Recommendation Report for Planning Permission

REF NO: M/140/21/PL

LOCATION: Flat 6 Middleton Court
57 Elmer Road
Middleton-On-Sea
PO22 6EH

PROPOSAL: Loft conversion to habitable use including the installation of 3 x rooflights.

DRAWING PLANNING DATE: SEPTEMBER 2021 DRAWN: T. Murray	SCALE 1/100 REVISION:

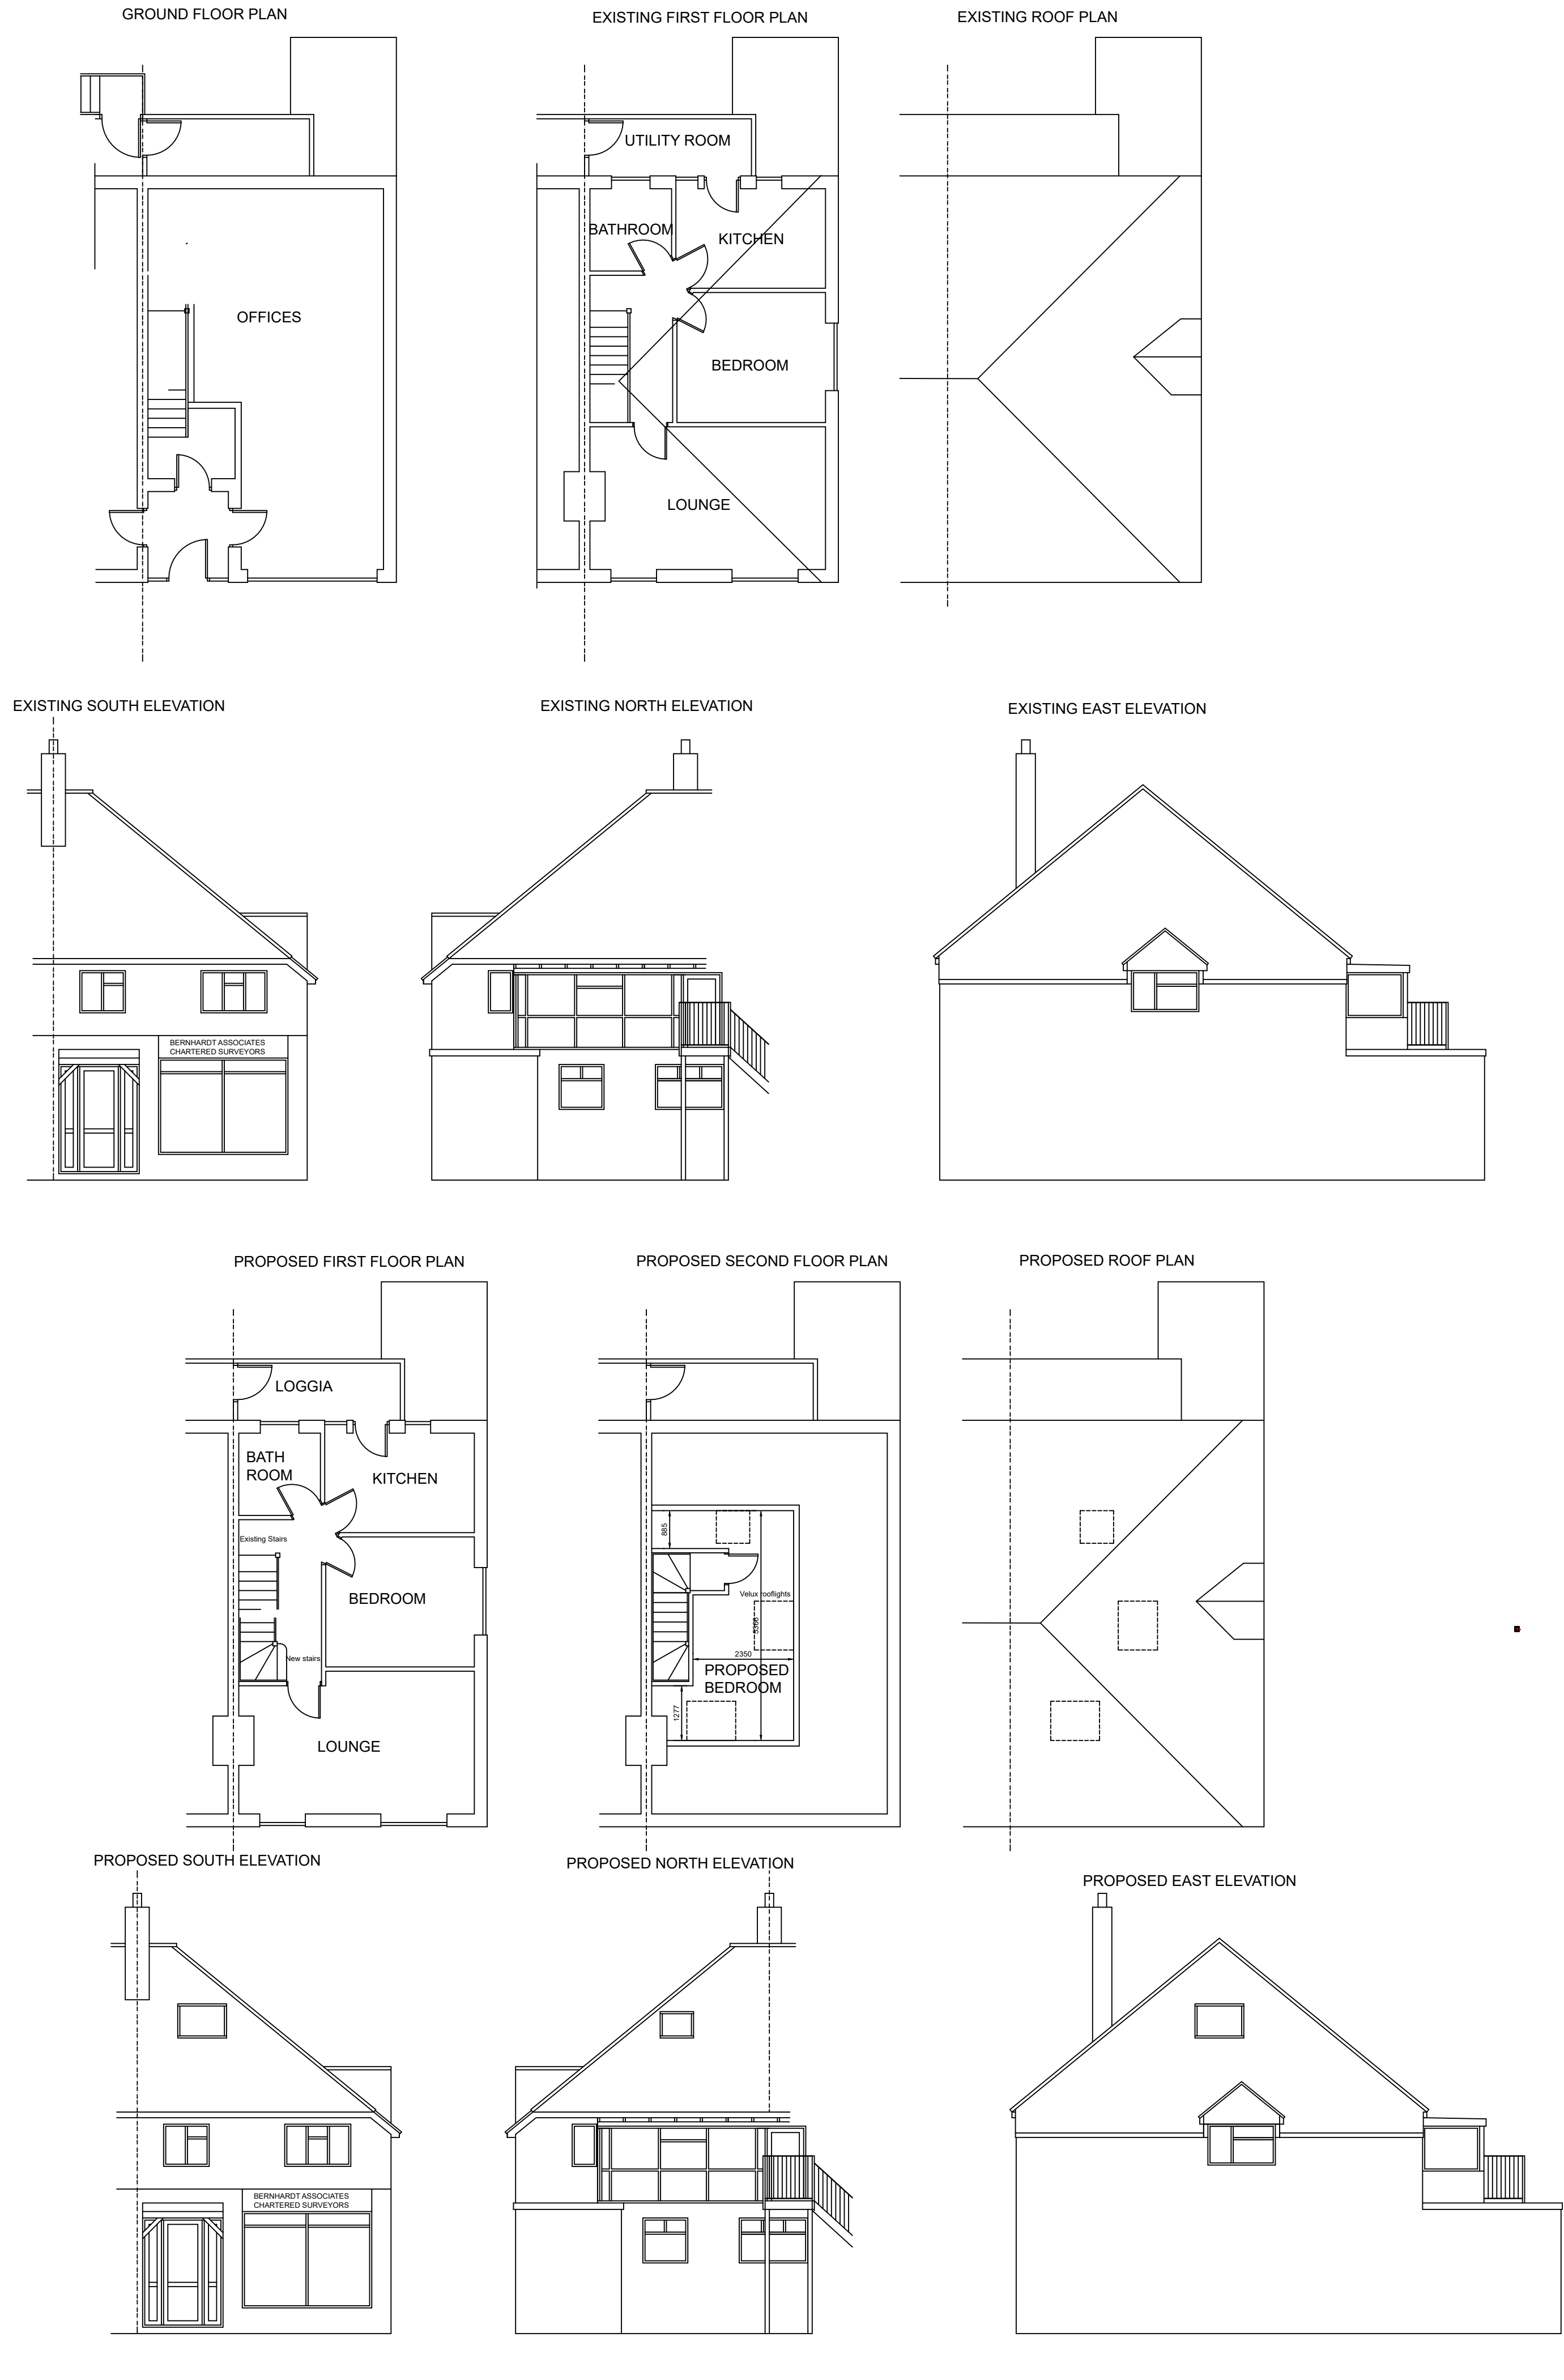
The external appearance of the building will remain largely unchanged except for 3 rooflights, one to each of the roof planes. The rooflights are considered to be visually integrated and subservient to the host dwelling.

There are 3 roof lights proposed, one to each of the roof elevations. The rooflight facing east will potentially have views of the neighbours property. In the interests of protecting privacy this will be conditioned to be fixed shut and obscure glazed below 1.7m above finished floor level. The roof lights facing north and south will only have views towards the public realm and over the rear of the property, as such are considered not to have a negative impact.

Reason: For the avoidance of doubt and in the interests of amenity and the environment in accordance with policy D DM1 and D DM4 of the Arun Local Plan and Part M of the Arun Design Guide.
- 3 The rooflight hereby approved to the eastern elevation shall at all times be glazed with obscured glass and only openable at a high level, at least 1.7m above finished floor level. The windows shall be retained as obscure glazed/non-openable in perpetuity.
